# Harbour Energy Deadline 5 Comments on Applicant's Submissions and Proposed Mitigation

Harbour Energy has reviewed and considered the submissions made by the Applicant over the course of the Morgan Generation Assets development consent order (DCO) Examination. There remain some material differences between the Applicant and Harbour Energy. As stated in Harbour Energy's Written Representation ([REP1-045](#)), Harbour Energy is committed to finding solutions that will allow the co-existence of its operations with other stakeholders, including the Applicant. To that end, Harbour Energy is committed to seeking pragmatic approaches to mitigate the adverse effects of Morgan Generation Assets. This document sets out the most material differences in view between the Applicant and Harbour Energy and proposes a pragmatic mitigation that could be implemented through Protective Provisions.

Figure A.1: Millom East Buffer Zones.

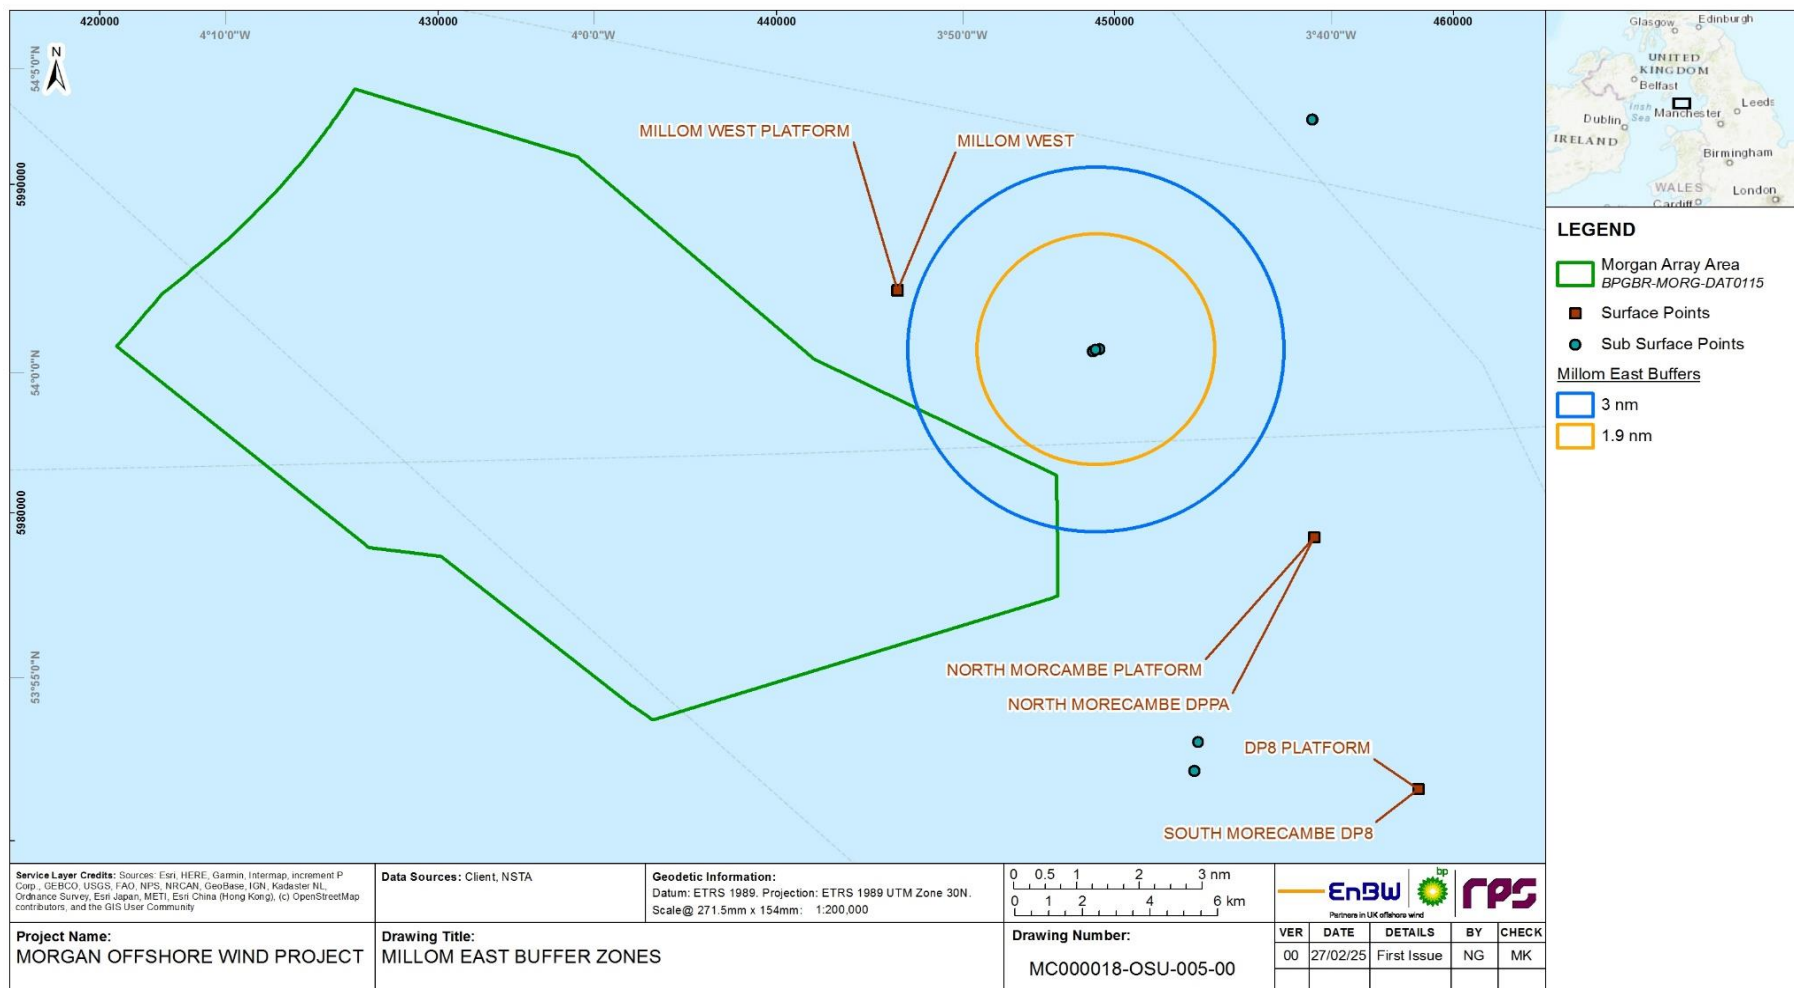
A potential mitigation to the disruption and economic loss arising from the impact of the Morgan Generation Assets was proposed in Section 2.2.2.1 of Harbour Energy's Written Representation ([REP1-045](#)) – namely that no wind turbine generators be placed with any part thereof (including rotor tips) within 3nm of the Millom East pipeline end manifold (PLEM). It should be noted that this would still result in a loss of 4% of currently available opportunities to fly to an NPI at Millom East as instrument take-off would still be affected.

An alternative mitigation would be a phased installation of the Morgan Generation Assets, leaving installation of the towers and rotors of those wind turbine generators to be placed within 3nm of the Millom East PLEM until the end of the installation programme (installation of foundations and transition pieces need not be delayed). This would increase the probability that Harbour Energy could complete the Millom East decommissioning without material impact from the Morgan Generation Assets.

- A "3nm buffer" shall be defined as the overlap of a circle of radius 3nm centred upon the Millom East PLEM and the Order Limits.
- Until the earlier of
  - o completion by Harbour Energy of Millom Field decommissioning; or
  - o completion by the Applicant of construction activities outwith the 3nm buffer, no construction of wind turbine towers and/or rotors shall be undertaken by the Applicant within the 3nm buffer.
